Re: Development Review Board Supplemental Submittal
Grace Covenant Church of God - Family Hall Addition Project
1700 57th Street NW, Albuquerque, New Mexico, 87105

On behalf of our Client, The Grace Covenant Church of God, we hereby submit this written description of the plan modifications made to the documents to address the DRB Review Comments dated February 21, 2018.

DESCRIPTION OF DRB SUBMITTAL COMPLIANCE WITH DRB REVIEW COMMENTS

TITLE: SITE DEVELOPEMENT PLAN
GENERAL ASSEMBLY CHURCH OF ALBUQUERQUE, N.M.

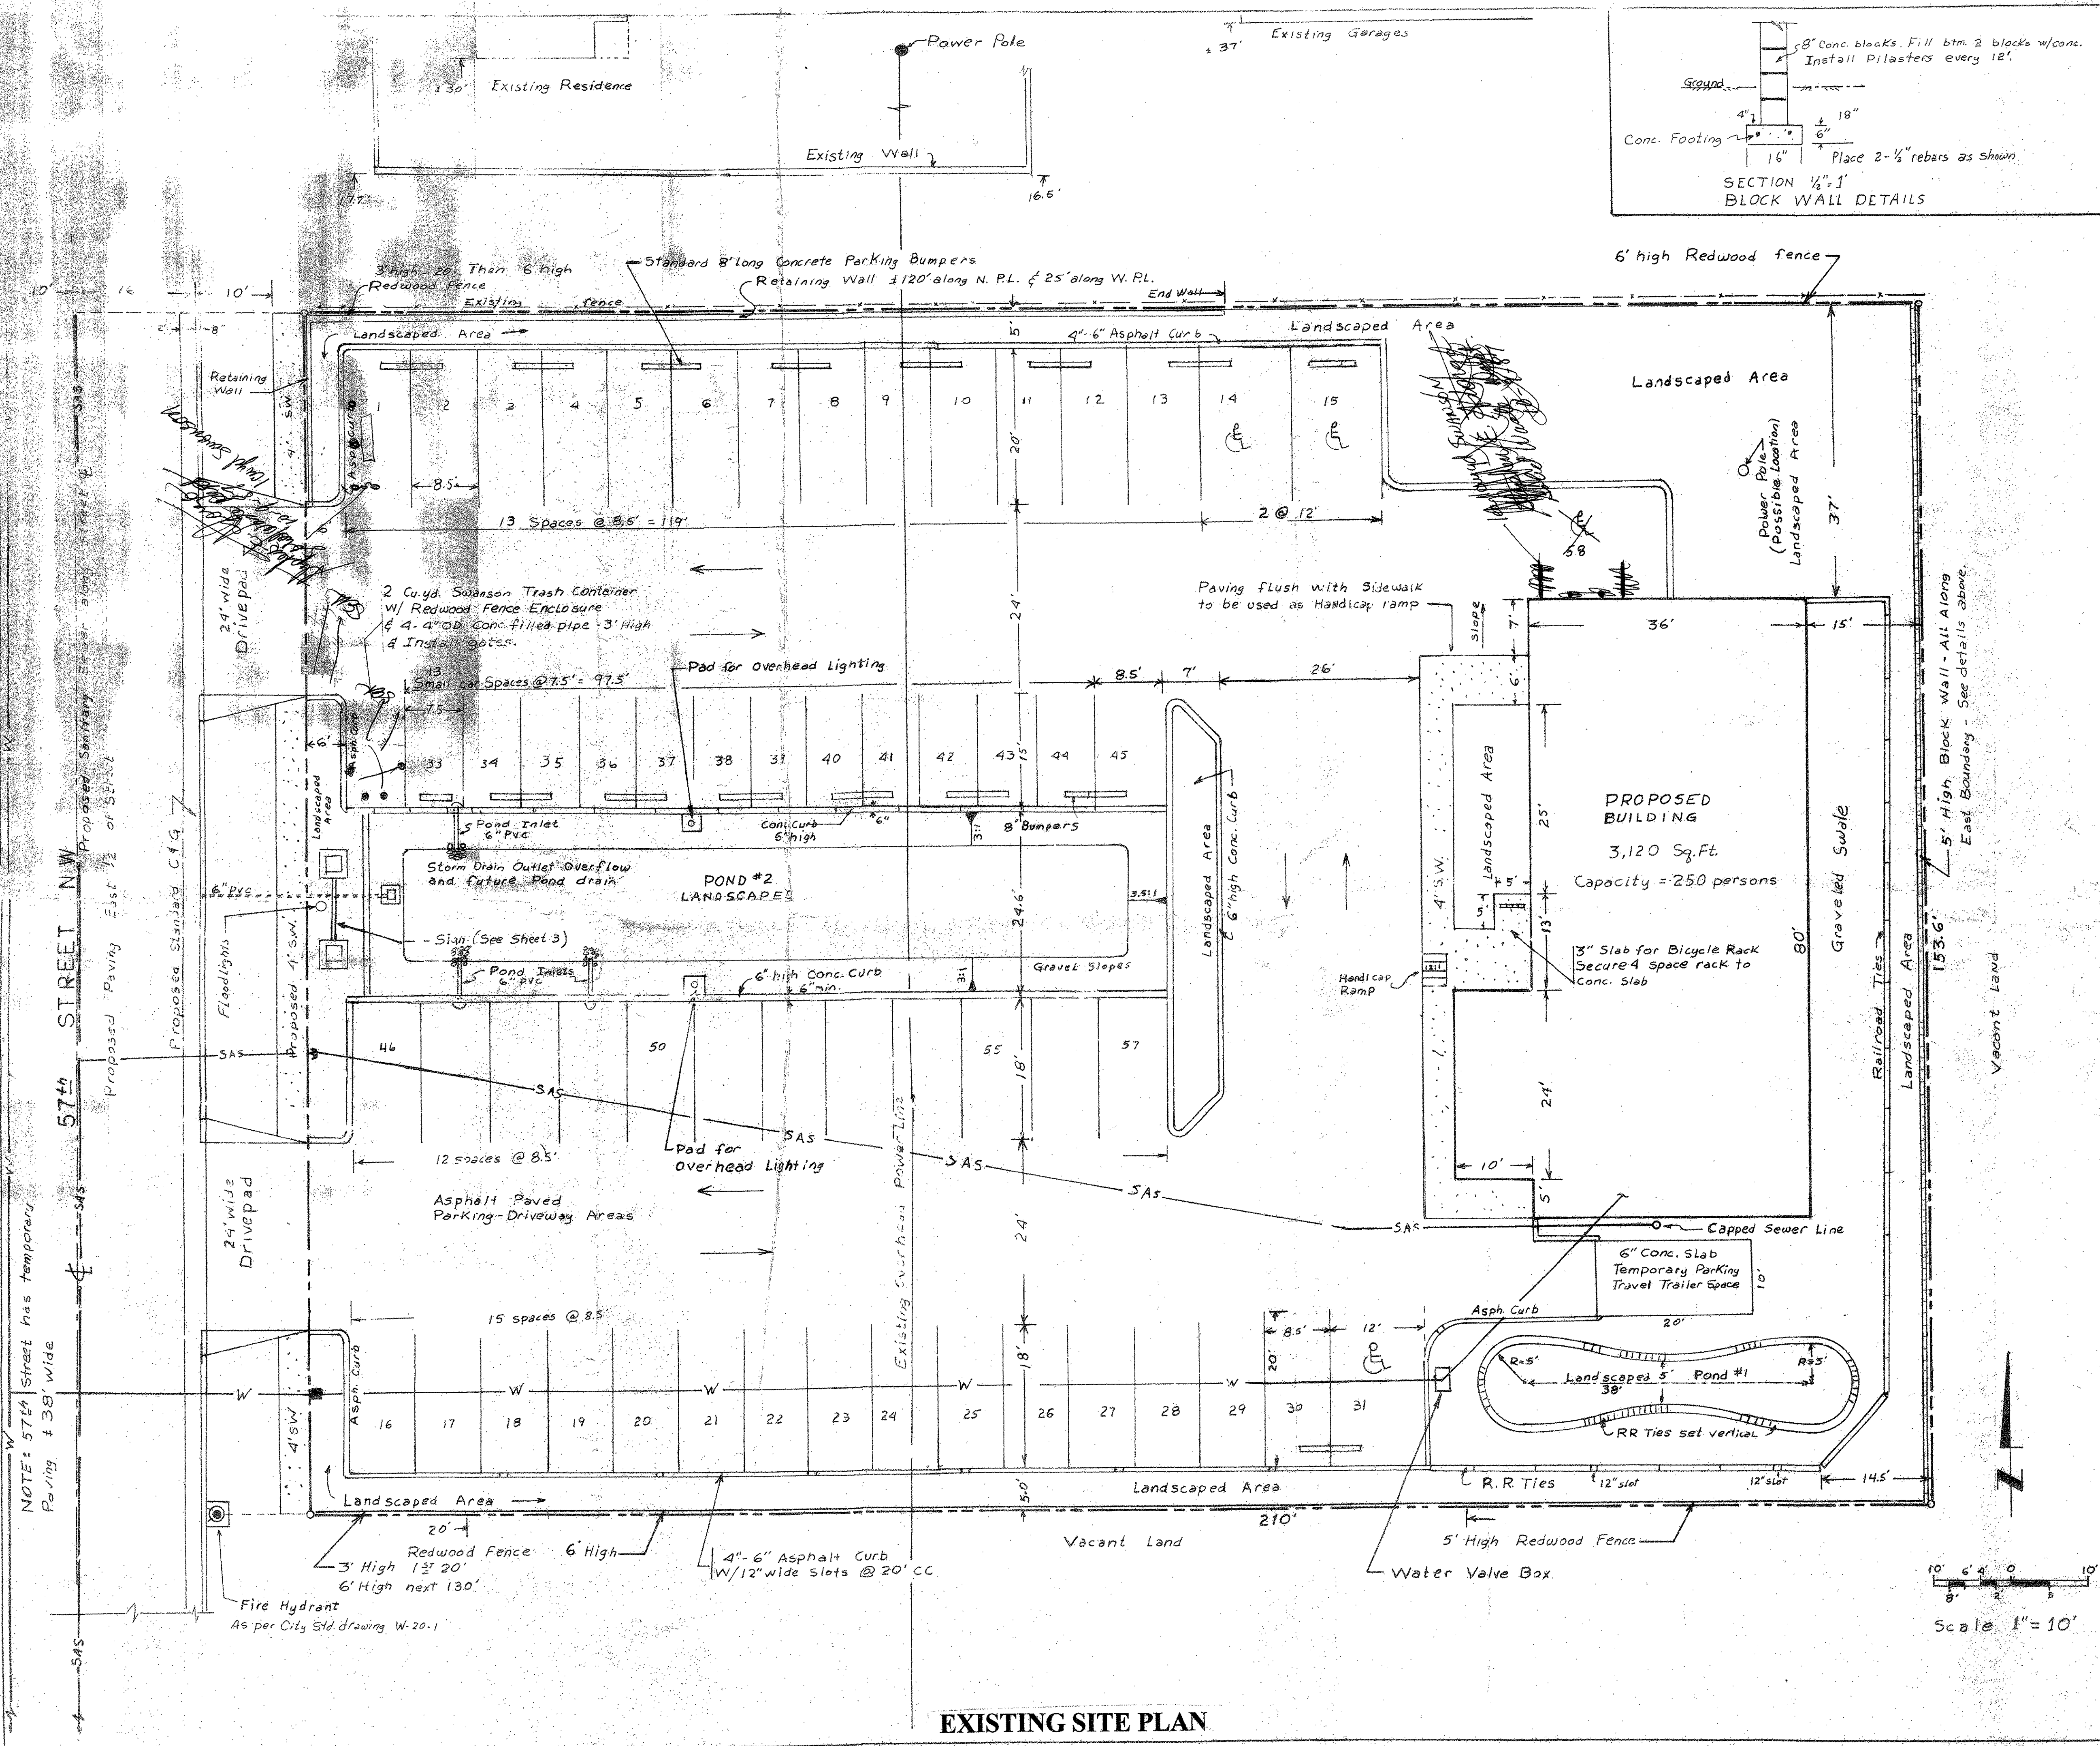
1. *"The ADA accessible spaces must be a minimum of 8.5 feet in width."*

2. *"The ADA accessible spaces must include an access aisle. Van accessible aisles should be 8 feet wide; all others should be 5 feet wide."*

3. *The ADA access aisle shall have the words "NO PARKING" in capital letters, each of which shall be at least one foot high and at least two inches wide, placed at the rear of the parking space so as to be close to where an adjacent vehicle's rear tire would be placed. [66-1-4.1.B NMSA 1978.*

4. *The ADA accessible parking sign must have the required language per 66-7-352.4C NMSA 1978 "Violators Are Subject to a Fine and/or towing." If that language is present it is not visible in the detail."*

1. *The Site Development Plan for Building Permit needs to show the fire hydrant at the SW corner of the subject property as a "New Public Fire Hydrant" with a 6" connection to the existing 8" water line on the west side of 57th Street NW.*

2. *The identification of the existing water line at the top of the Site Development Plan needs to identify the existing water line as an 8" line, not a 6" line."*

The Site Plan has been amended to indicate three 8'-6" wide accessible parking spaces.

The Site Plan has been amended to indicate a van access aisle of 8'-0" width and a single 5'-0" wide aisle for the standard sized HC parking spaces.

The Site Plan has been amended to indicate the required NO PARKING verbiage and noted to describe the required height and size of the lettering.

The Site Plan has been amended to indicate the required signage locations of the signage. The plan has been noted to describe the required verbiage.

The Site Development Plan has been amended to indicate the actual location of a second fire hydrant located at the NE corner of 57th Street and Bice Rd. The hydrant indicated on the EPC approved plans was never constructed. The existing hydrant has been located dimensionally and has been approved by the Fire Department as a compliant second hydrant and the Site Plan has been reviewed and stamped accordingly. The distance between the two existing hydrants is approximately 285 feet which is well within the 500 foot distance between hydrants as delineated in the current Fire Code, Appendix C, Fire Hydrant Locations and Distribution, Table C102.1. The applicant requests that the existing fire hydrant be approved by the Water Authority and the hydrant indicated on the EPC approved plan has been crossed out in anticipation of the ABCWUA approval. The water line size in Bice Rd. has been noted as an existing 14" line with the required 6" connection to the hydrant.

The Site Plan has been amended to indicate the existing line as an 8" line.

TITLE: LANDSCAPING PLAN
 JEHOVAH'S WITNESSES
 KINGDOM HALL WESTSIDE CONGREGATION

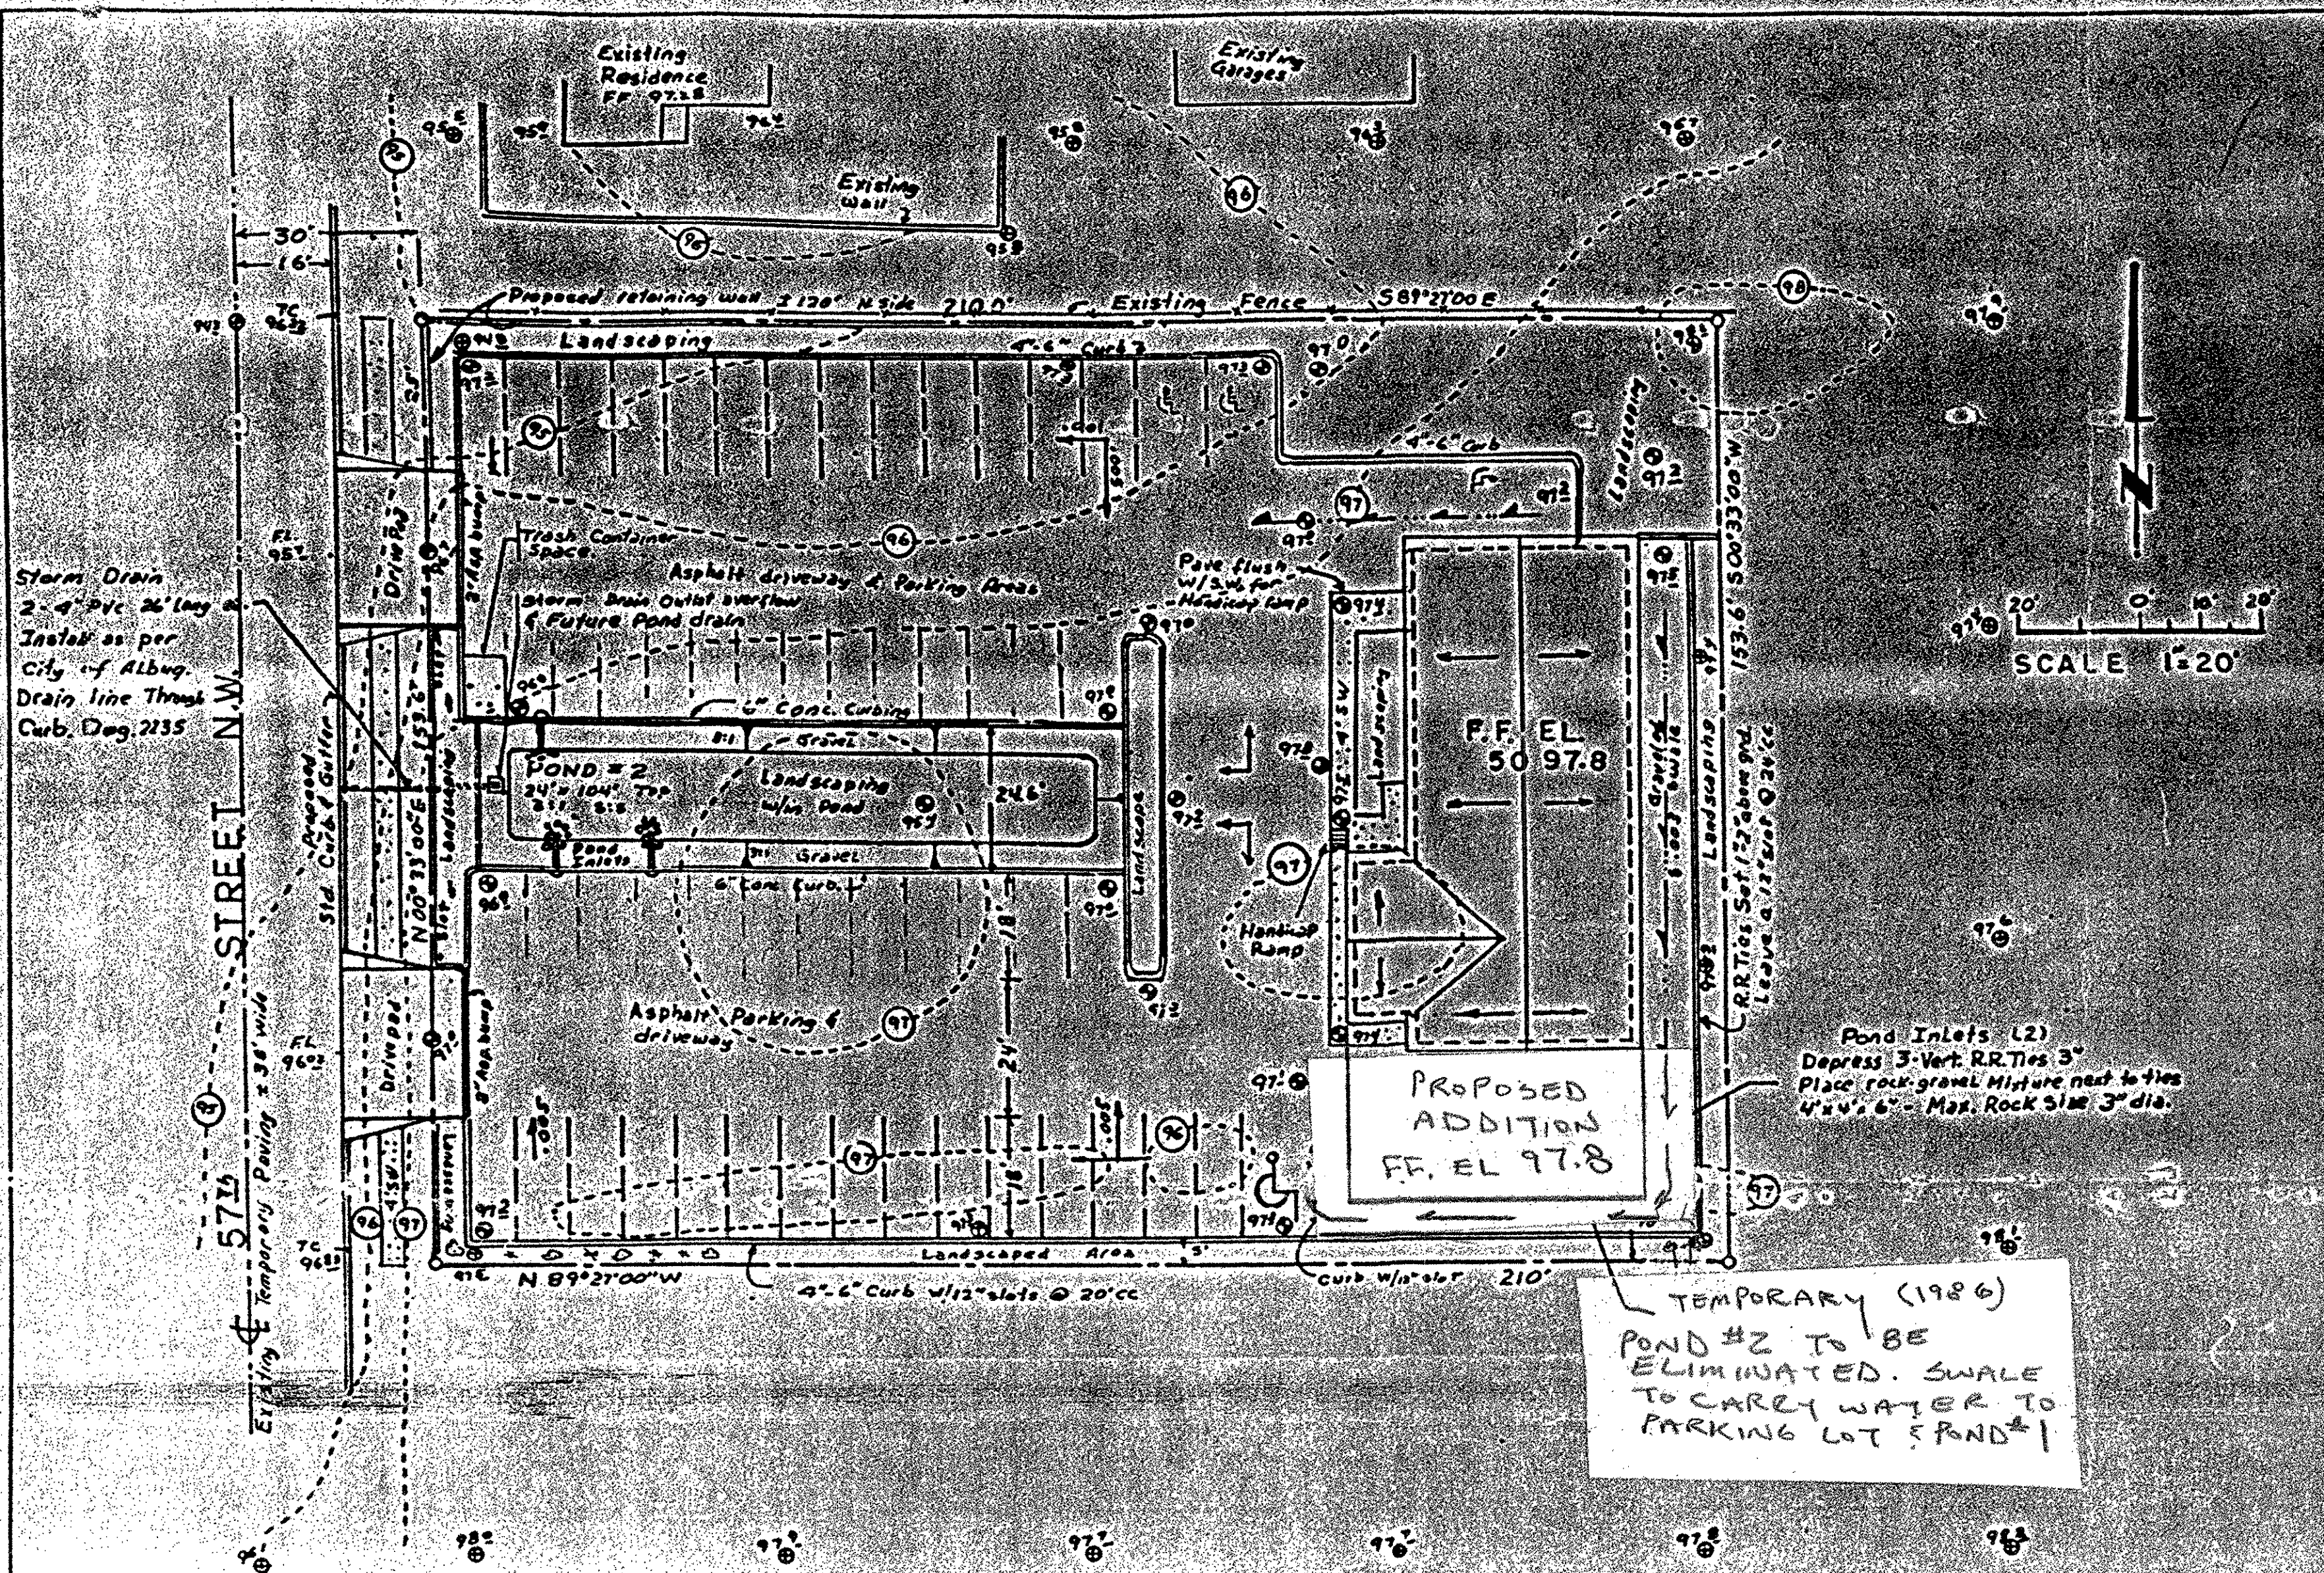
- *4. Landscaping: c and f. Planting beds shall achieve 75% coverage of live plantings – currently [AGIS Aerial] the site does not meet this requirement. A note was added to address conditions 4c and 4f. Additional planting will be required to ensure compliance since currently the site does not comply. There are no plantings along the southern boundary abutting the parking lot. The northern looks like about 25%. If additional plantings are not installed, a Notice of Violation will be issued.*

The landscaping note added to the Landscape Plan indicates that the planting beds in question will meet the 75% coverage requirement. Additional notations have been added to the plan at the north and south property lines indicating the number of plants to be installed which will meet that requirement at maturity. The planting attrition identified by the above comment will be addressed by additional plantings. The note indicating "All existing landscaping to be left as existing" has been crossed out. Existing landscape areas in compliance with the required coverage will be left in place and maintained by the Owner.
